Application number: 2019/90397	
What is the application for?:	Erection of front and rear single storey extension and dormers to side
Address of the site or building:	2, Squirrel Hall Drive, Dewsbury, WF13 4AH
Postcode:	WF13 4AH

PROPOSED GROUND FLOOR PLAN

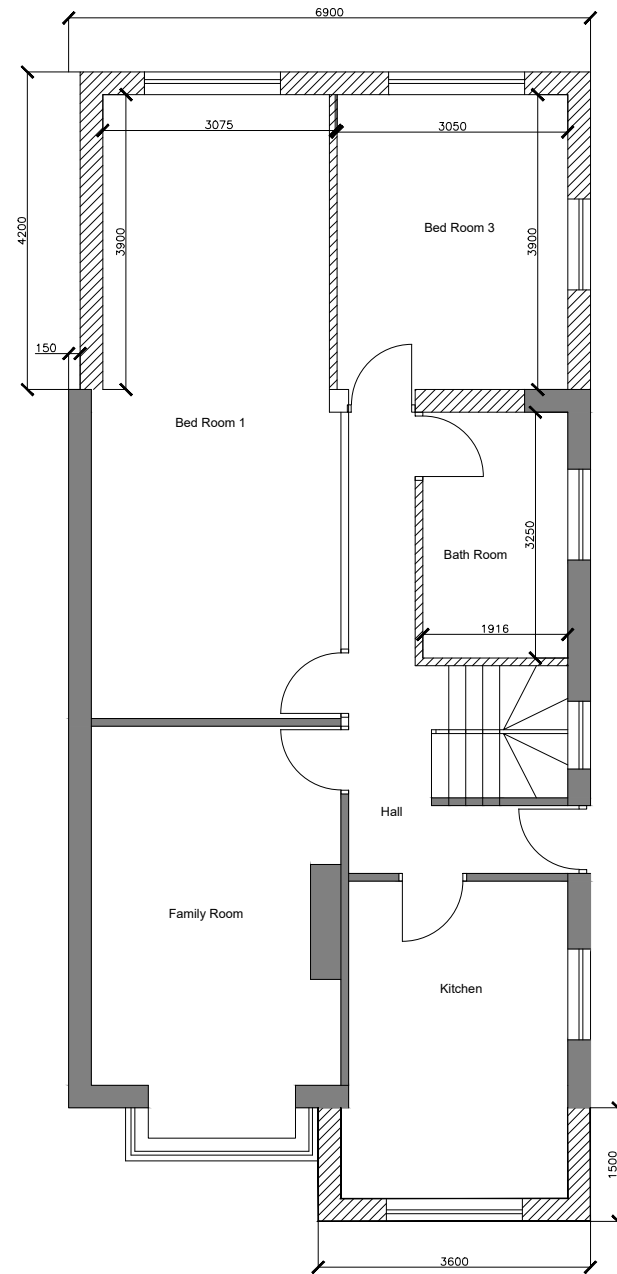
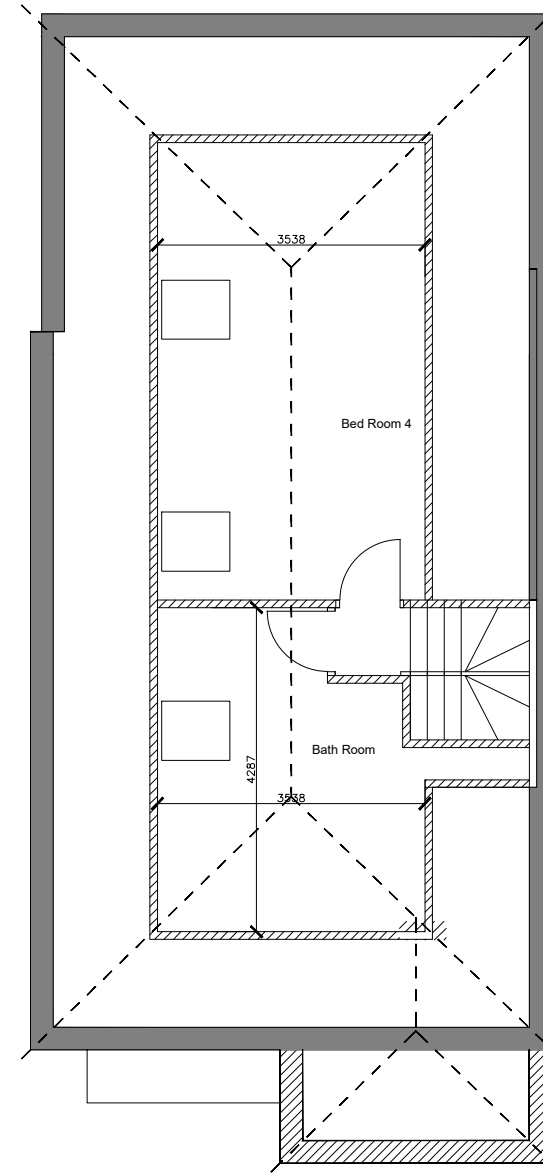
Type of comment: An objection
<p>The proposed planning application should be denied for the following reasons.</p> <p>The proposed extension to the front of the property, although smaller in scale than the previous proposal, will still have an unacceptable impact on the visual amenity and character of the local street scene, these being two important points in planning.</p> <p>As Squirrel Hall as a very linear arrangement the proposal will be out of character with both the host property and the street scene.</p> <p>The proposal will create a very awkward, unattractive detail on the property. The bay will in effect disappear and be replaced with another projection to one side creating an unattractive junction. Furthermore the flat roof detail of the existing bay will be flanked by both the walls and roof of the proposed structure.</p> <p>This means that front of the property will have three face planes - the existing brickwork to one side of the bay followed by the projection of the bay followed by a further forward projection of the proposed new brickwork. The appearance of the roof will also be subject to this visual effect, especially when coming up the street, where the hip of the proposed roof will clearly be visible. There is nothing like that anywhere on the Squirrel estate and as such it will be incongruous with the long established (50+ years) street scene.</p> <p>The rear extension is 40% larger than the recommended size for consideration under section BE14 of the UDP. It will take the rear of the property to within 1.5m of the boundary, which consists of a small stone along with an hedge which is approx 8-10 metres high. The small brick boundary wall to the property on Cullingworth street shows signs of being displaced by the root system of the hedge.</p> <p>The size of the proposed rear extension means removing a parking area, which is presently been used as such. It will be extremely difficult, without alterations, to use the side of the house for parking, especially as there has been occasions where 2 vehicles have been parked at the property.</p> <p>The proposed dormers do not comply with BE15 i,ii and iii. which are required for consideration and due to the prominent location of the property will form an incongruous feature within the street scene.</p>
